**RE: Stanford Court (424 Stanford Drive SE)
Grading & Drainage Plan
Engineer's Stamp Date 2-9-16 (File: K16D084)**

Based upon the information provided in your submittal received 2-10-2016, the above referenced Grading and Drainage Plan is approved for Foundation Permit, Grading Permit, Paving Permit, and conditionally approved for Building Permit.

**RE: Stanford Court (424 Stanford Drive SE)
Grading & Drainage Plan
Engineer's Stamp Date 1-7-16 (File: K16D084)**

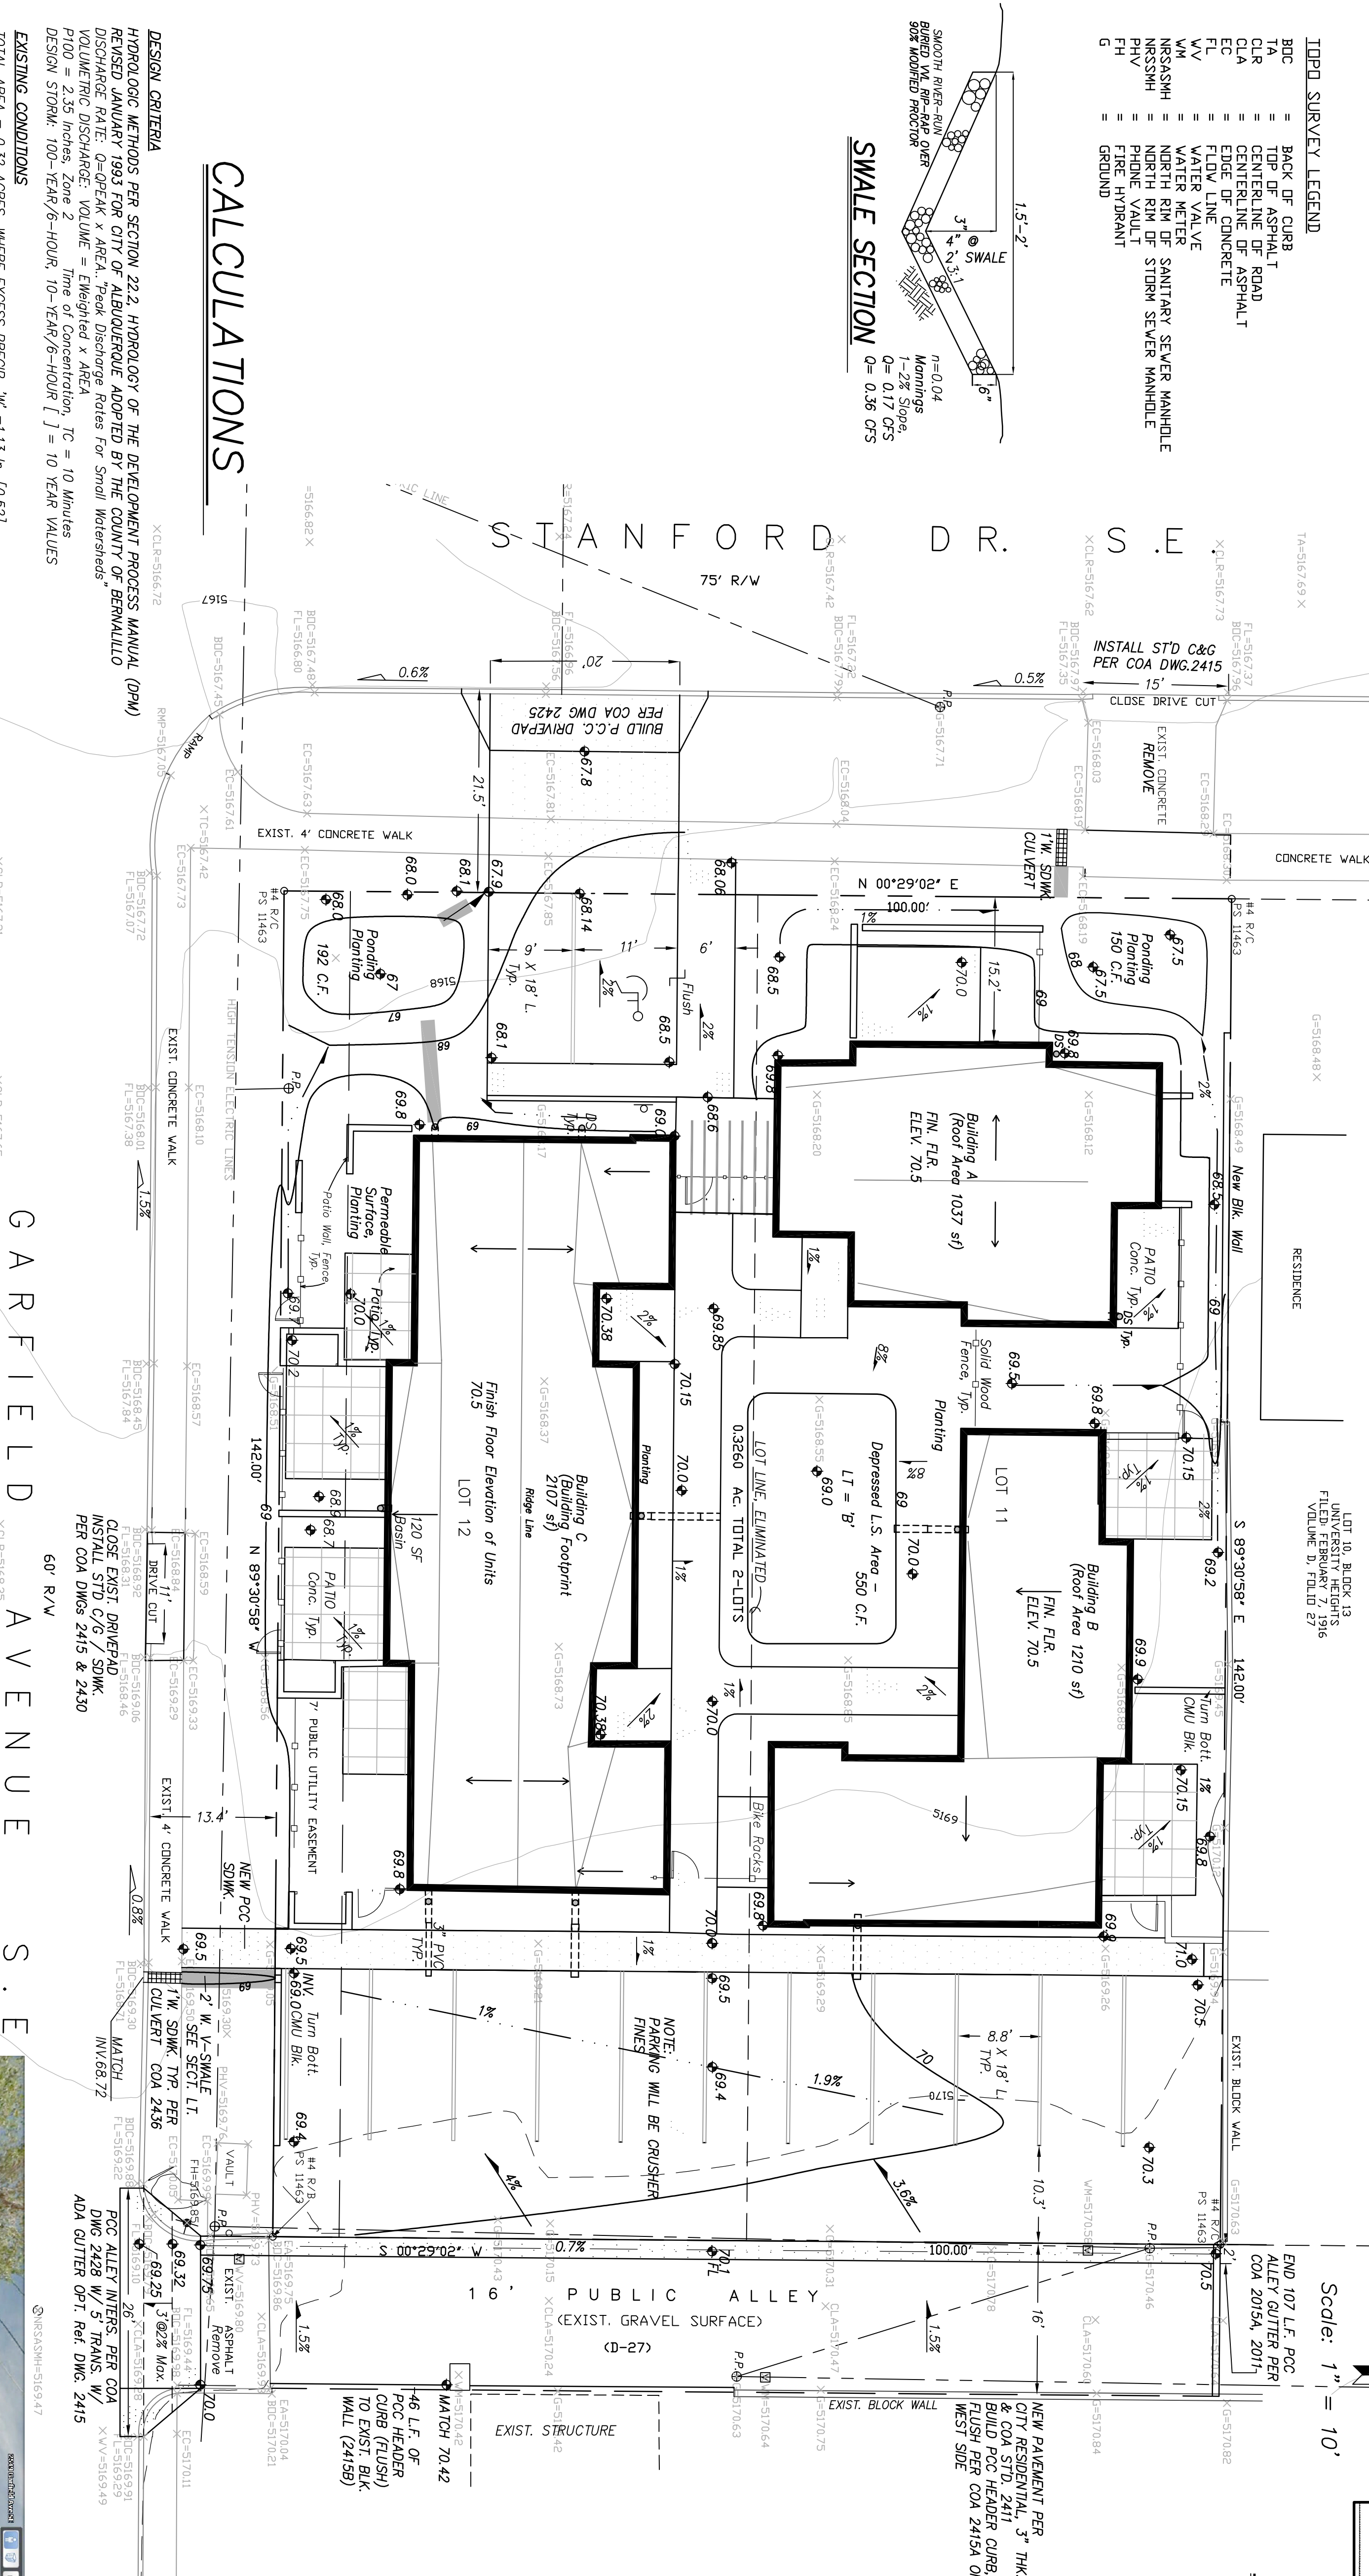
- b. The volume calculation of the 100-year, 6-hour storm should be 1821 cubic feet, not 1812 cubic feet (per a quick calculation completed based on the plan's land treatments and dimensions). Furthermore, it is not clear why these volume calculations are provided, they do not correlate with the proposed total volume provided.

Drawing file: K16D084 / K16D084_Rev_BP_SO19_CMMT.pdf

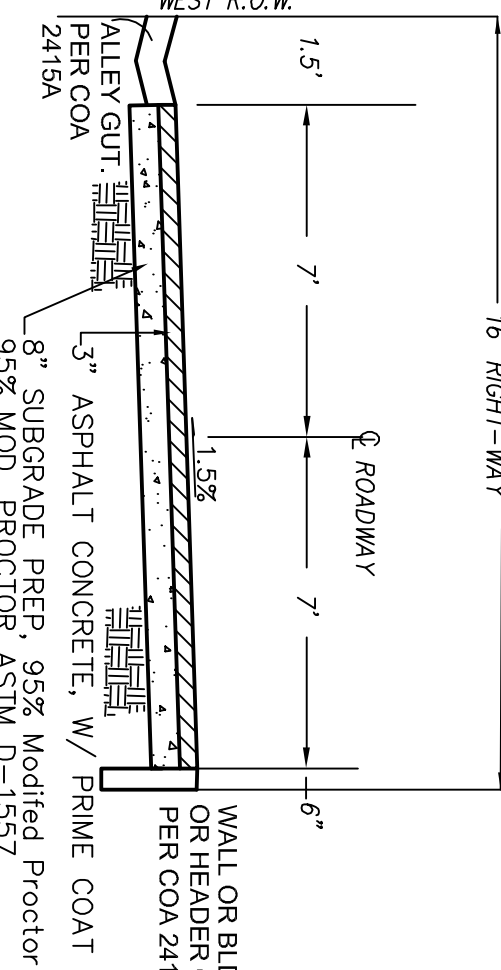
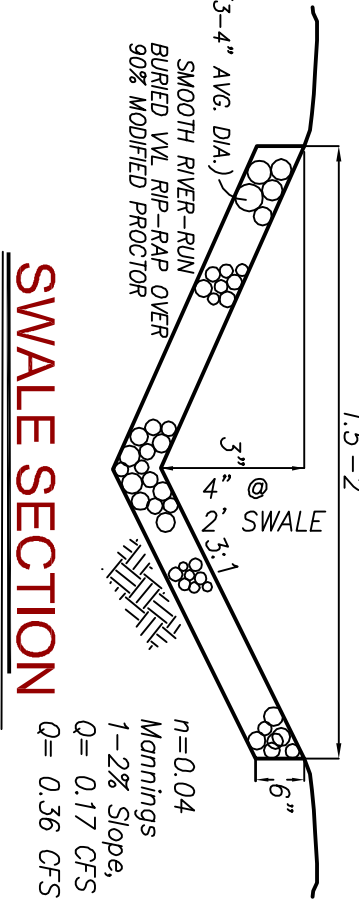
- The plan needed to have the SO-19 notes, and the
- Sidewalk culvert needs to be extended 6" behind the sidewalk to avoid a drop-off behind the sidewalk.

2. That the two sidewalk culverts in City Right of Way are extended 6-inches behind the sidewalk.

PS: I concur with the excellent comment to extend the sdwk culverts - thanks
